**Consultation Response from KC,
Highways Development Management**

2024/91998 former, Almondbury High School, Fernside Avenue, Huddersfield, HD5 8PQ

Erection of special educational needs and disabilities school (Use Class F1), comprising educational buildings, roof mounted photo-voltaic panels, sensory garden spaces, multi- use games areas, landscaping, hardstanding areas, carparking, access with secure fencing and associated ancillary development

Date Responded: 07/11/2024

DRAWING NUMBER :	STATUS :	REVISION :
22315-ALA-00-XX-DR-L-0010	S2	P02

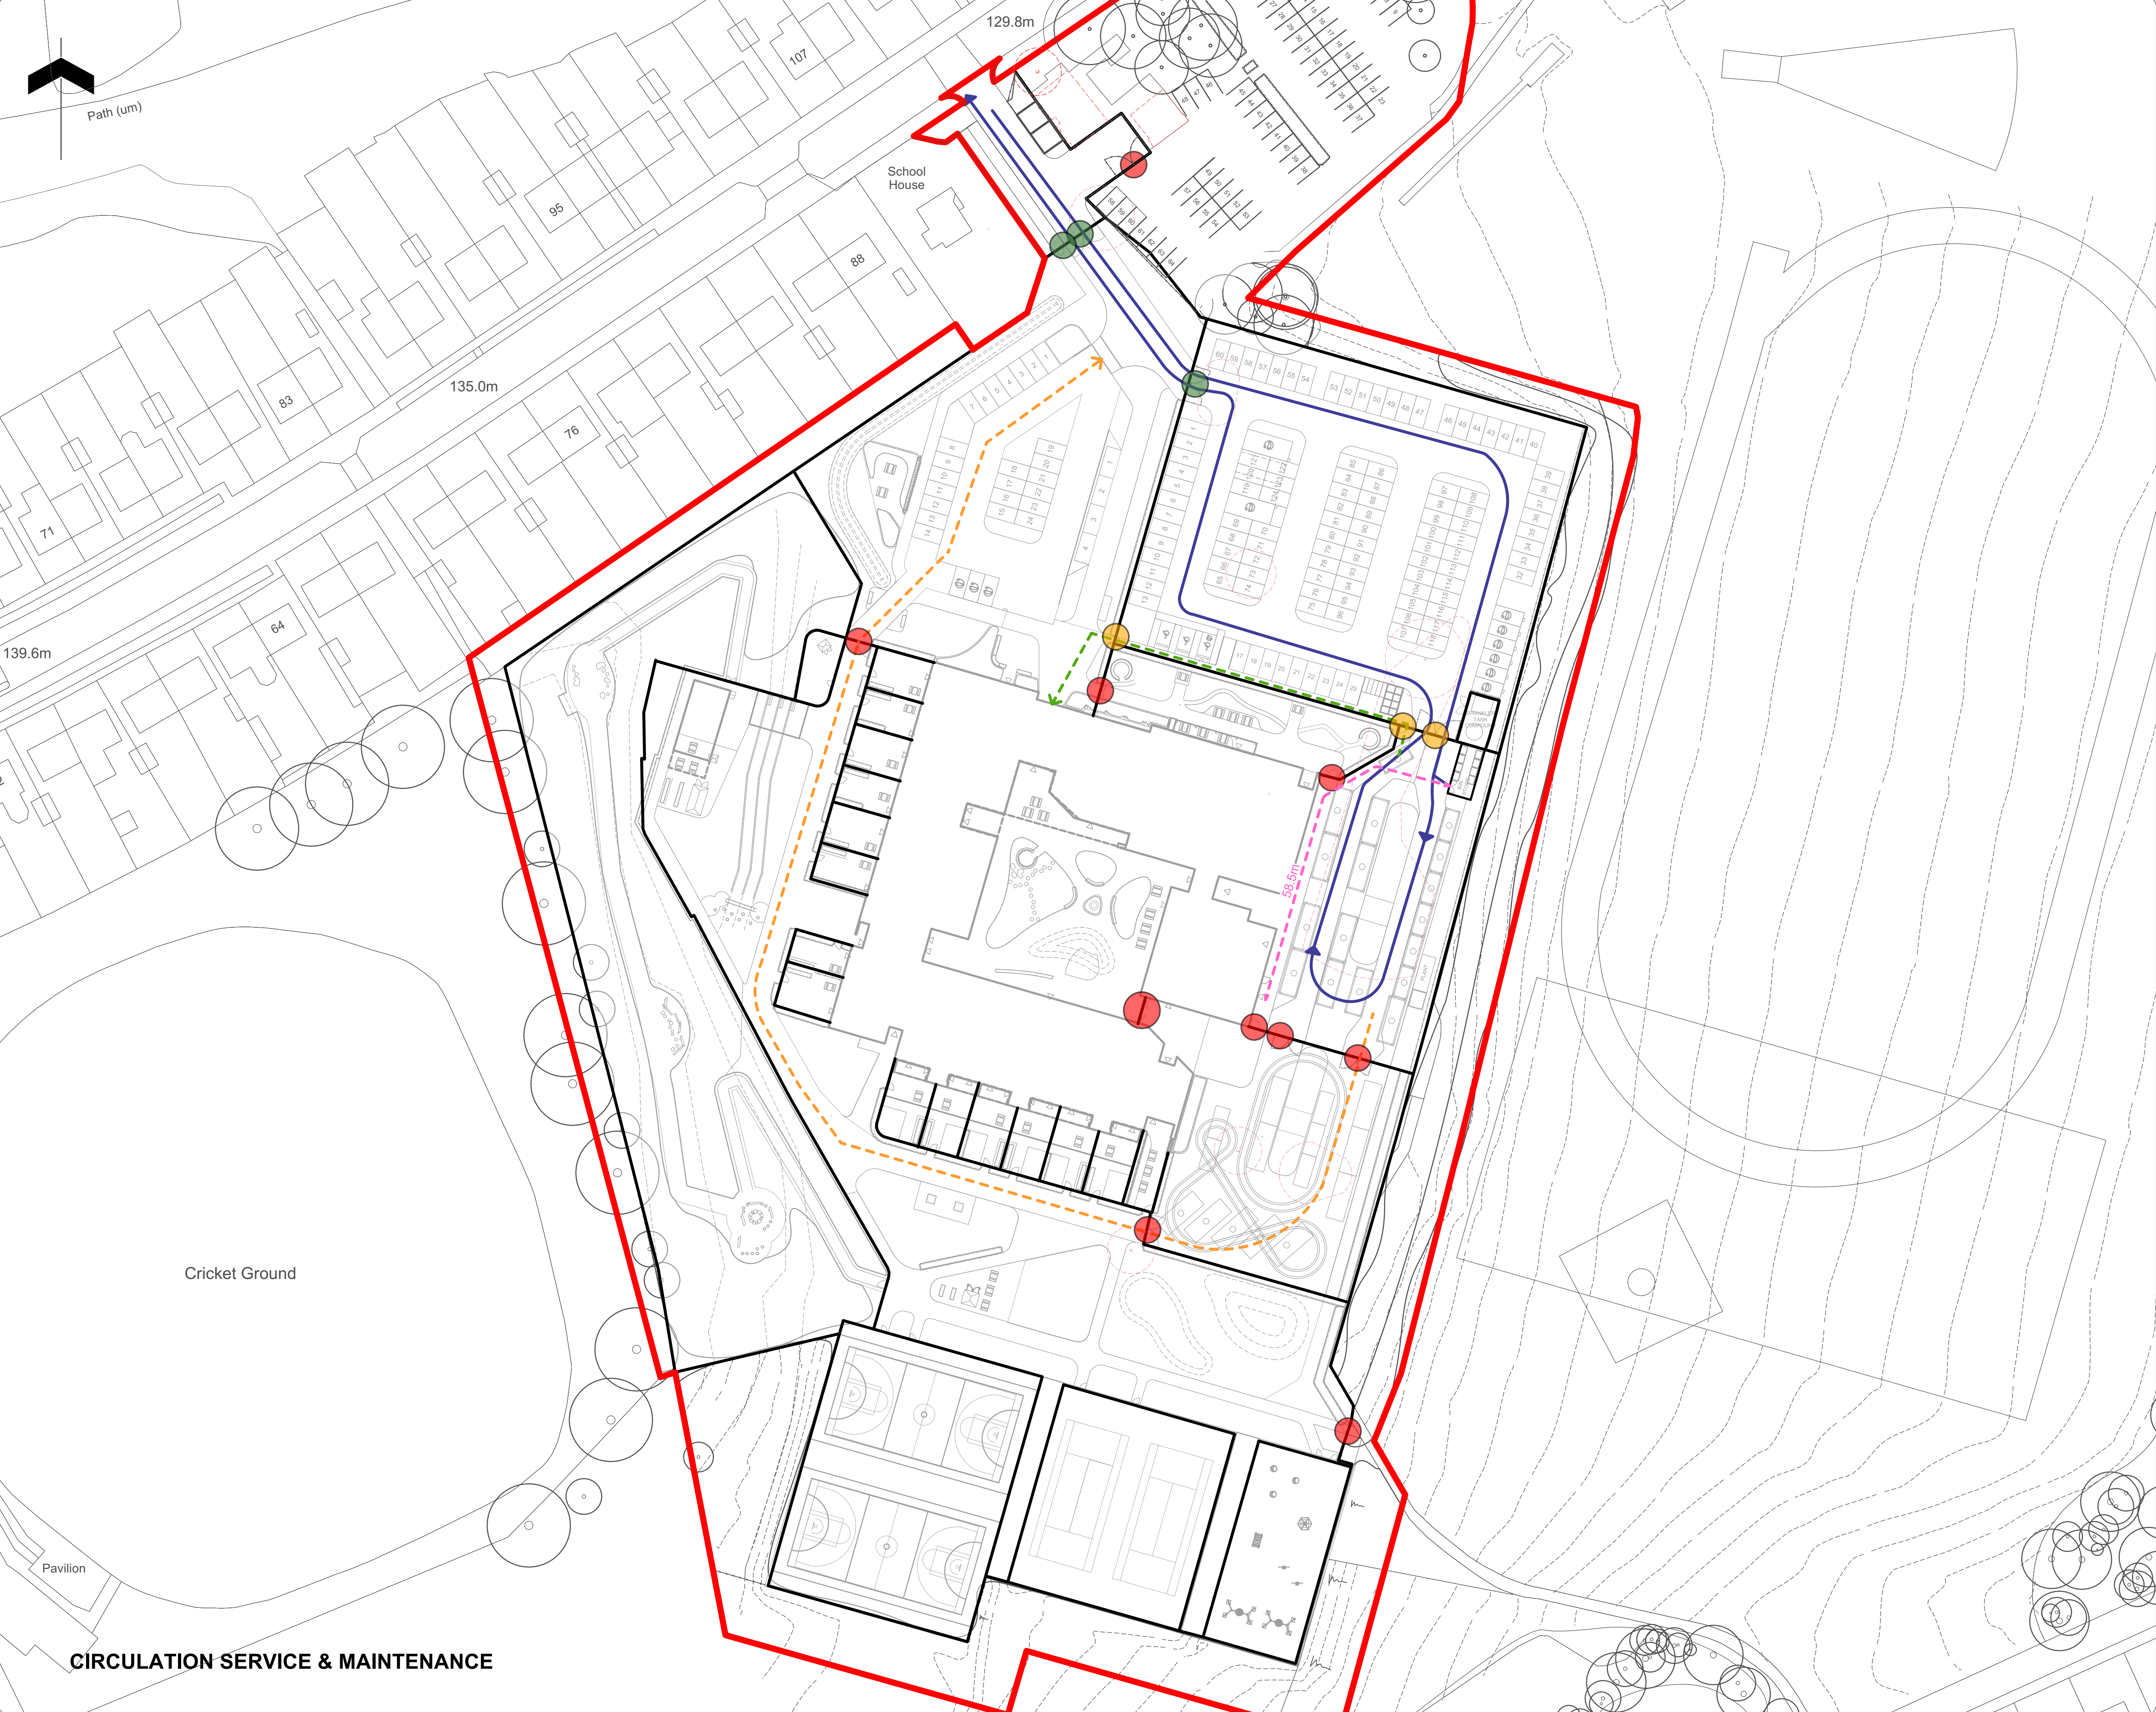
The only concern that was raised at pre-app and doesn't appear to have been addressed with the application was the access in to the car park adjacent to the nursery building. This contains a sharp right-hand turn from the side of the proposed turning head that may not be safe for larger maintenance vehicles needing to access the site. We requested that a swept path is provided to show that a maintenance/servicing vehicle can access the site safely or that the access is redesigned to a straight access. These details should be provided and can be added as a pre-commencement condition.

Notwithstanding the details shown on the approved plan, no development shall take place until a scheme detailing arrangements and specification for layout of the access to the adjacent parking area (nursery site), including a swept path analysis, have been submitted to and approved in writing by the Local Planning Authority. Before any building is occupied the development shall be completed in accordance with the details shown on the approved plans and retained thereafter.

DRAWING NUMBER: 22315-ALA-00-XX-DR-L-0012	STATUS: S2	REVISION: P02
---	----------------------	-------------------------

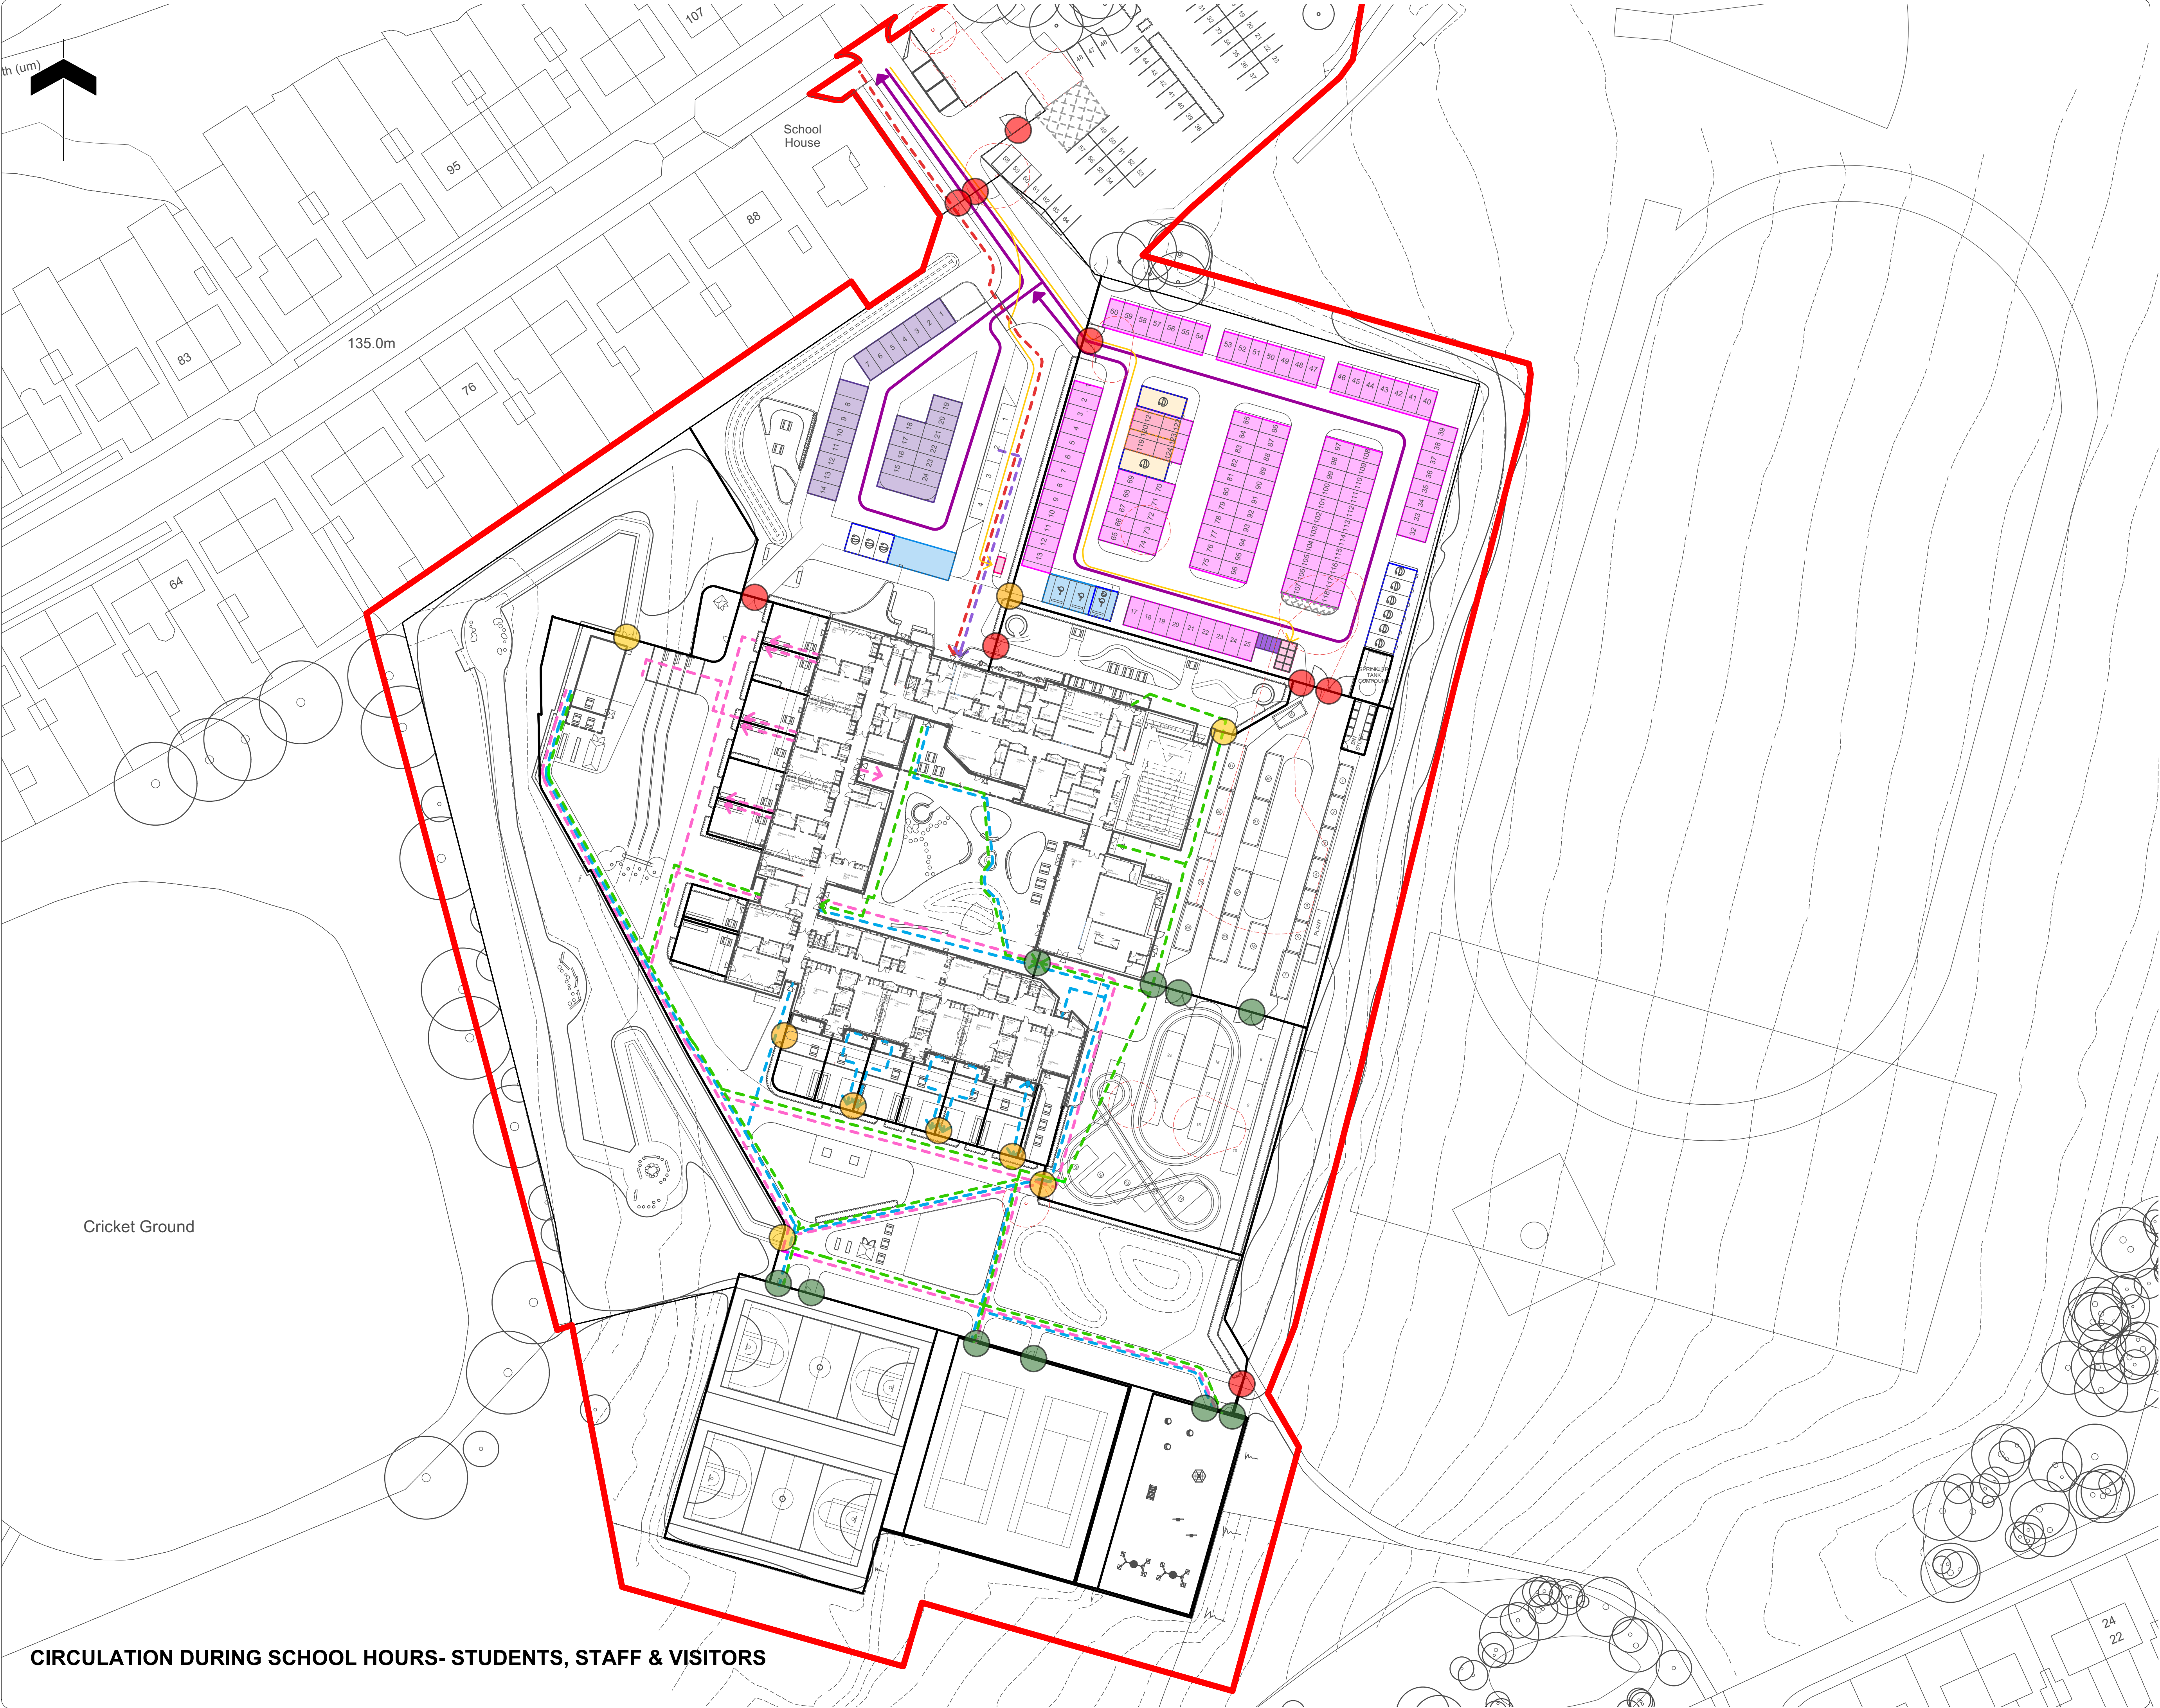
The proposed parking provision, shown on drawing No 0012 S2 P02 is for 111 staff car parking spaces, 24 visitor parking spaces, 6 accessible spaces, 9 EV parking spaces and, from the Transport Statement, up to 25 mini-bus spaces and 6 taxi spaces and these were based on the proposed number of staff (166) and students (180), with most student arrivals being by mini-bus. The spaces are all of a suitable size with a 6m headway to allow easy and safe manoeuvring in and out of the spaces. Drawing No 0001 S2 P04 indicates that 10 covered cycle spaces are to be provided, however no details have been provided of the cycle storage and so we would request that these are provided as part of a condition.

Before development commences, details of suitable cycle storage facilities shall be submitted to and approved in writing by the Local Planning Authority. The approved details shall be provided before first occupation and shall be so retained thereafter.
